**RE: 4605 Albany NE**  
**Grading Plan**  
**Stamp Date: 9/27/17**  
**Hydrology File: B12D014**

Based upon the information provided in your submittal received 09/27/2017, the Grading Plan **is not** approved for Building Permit and Grading Permit. The following comments need to be addressed for approval of the above referenced project:

ENGINEER'S SEAL  10/17/17 9/27/17 DAVID SOULE P.E. #14522	4605 ALBANY COURT N.W.	DRAWN BY WCWJ
		DATE 9-26-17
	GRADING AND DRAINAGE PLAN	21803-LAYOUT-9-26-17
 Rio Grande Engineering 1606 CENTRAL AVENUE SE SUITE 201 ALBUQUERQUE, NM 87106 (505) 872-0999	SHEET # ---	
	JOB # 21803

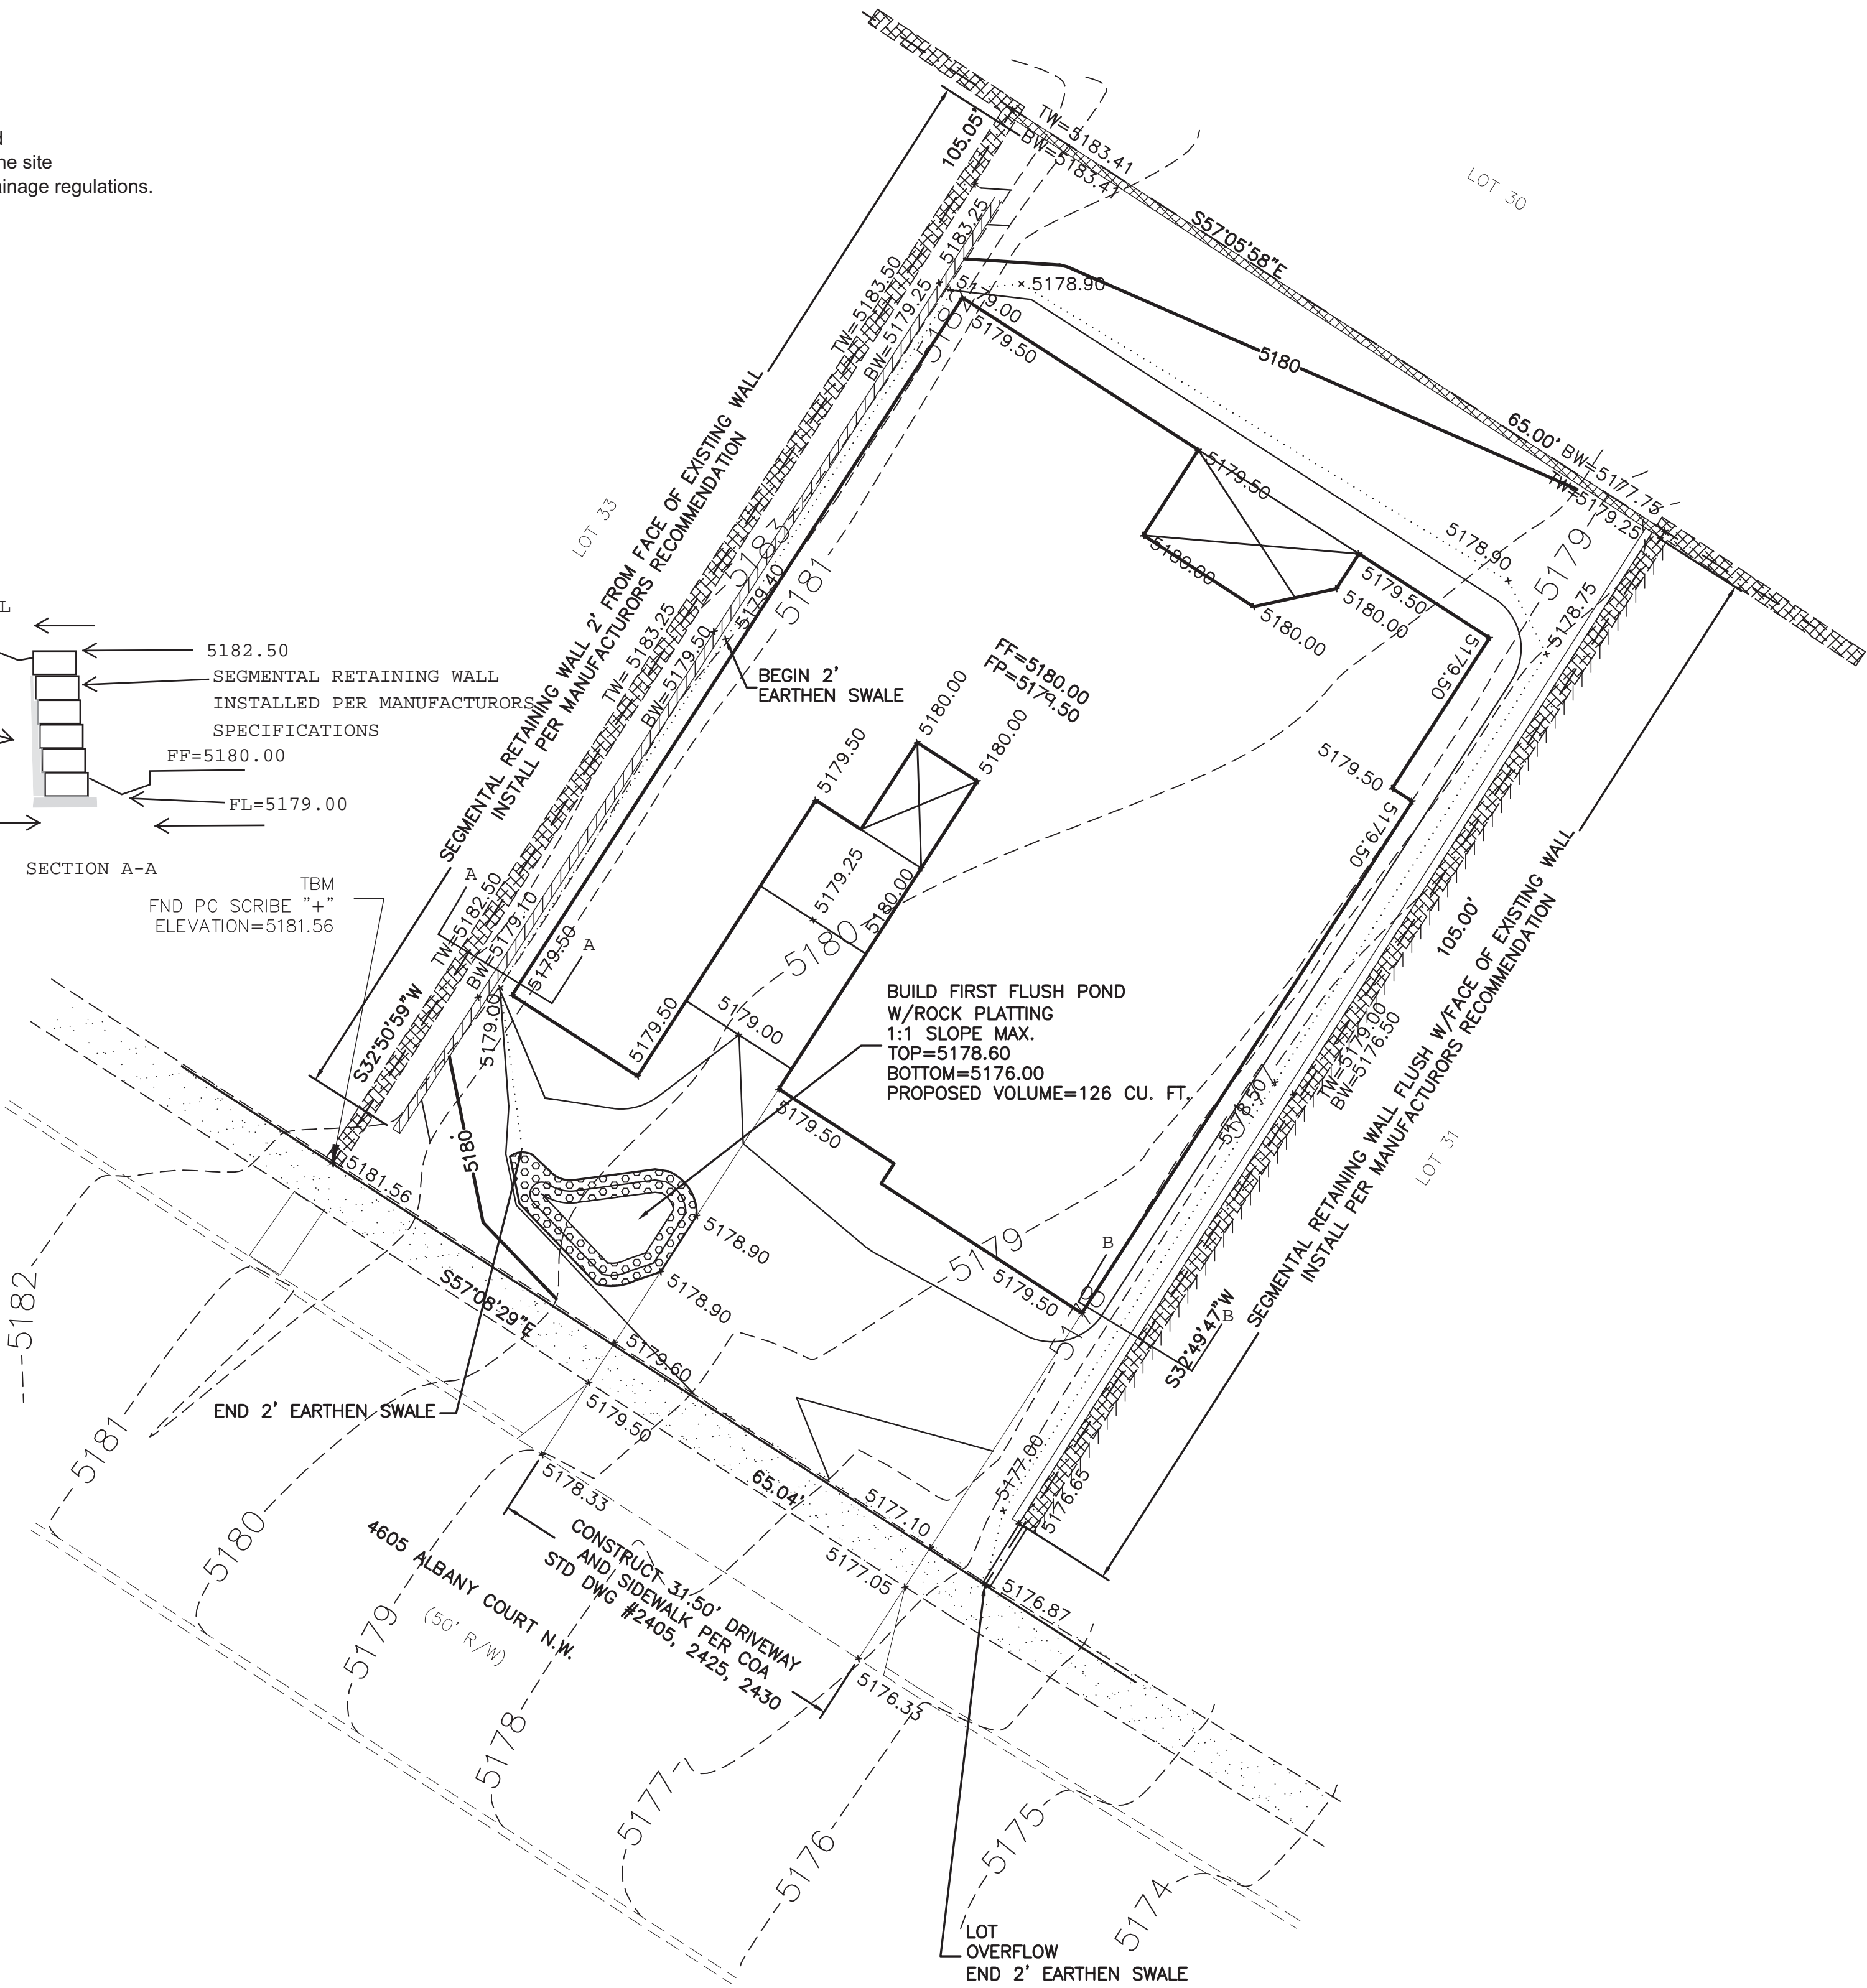
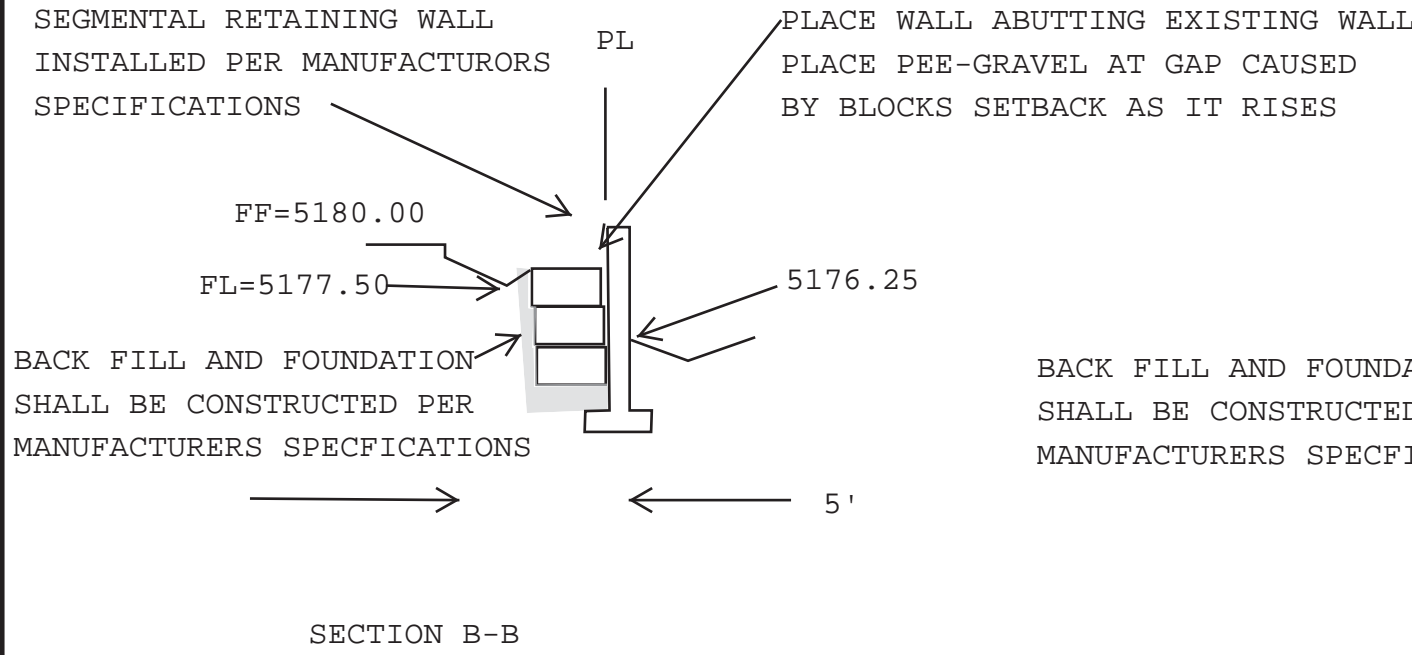
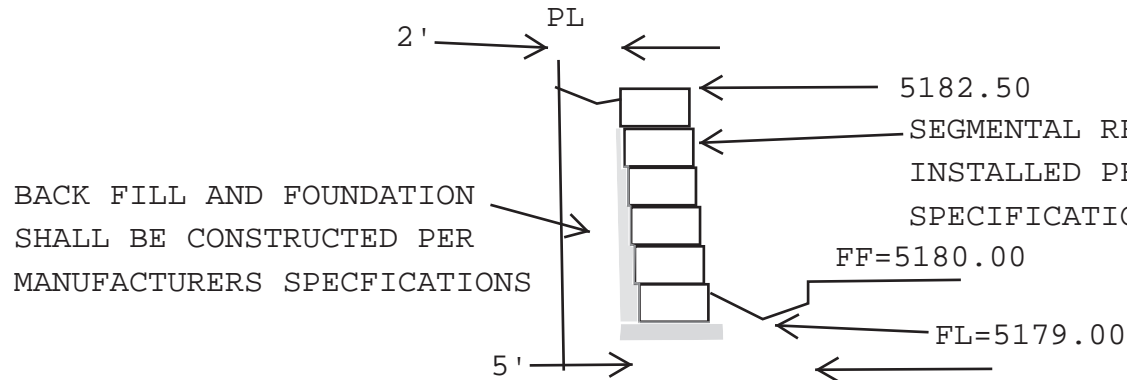
1. Please provide a cross section for both proposed retaining walls. Please include the existing retaining wall, the property line, and footer information. I'm epically concerned about the East wall since you are putting this flush with the existing wall. I want to ensure the integrity of the existing retaining walls. See Attached sheet for the location of the cross sections in question.
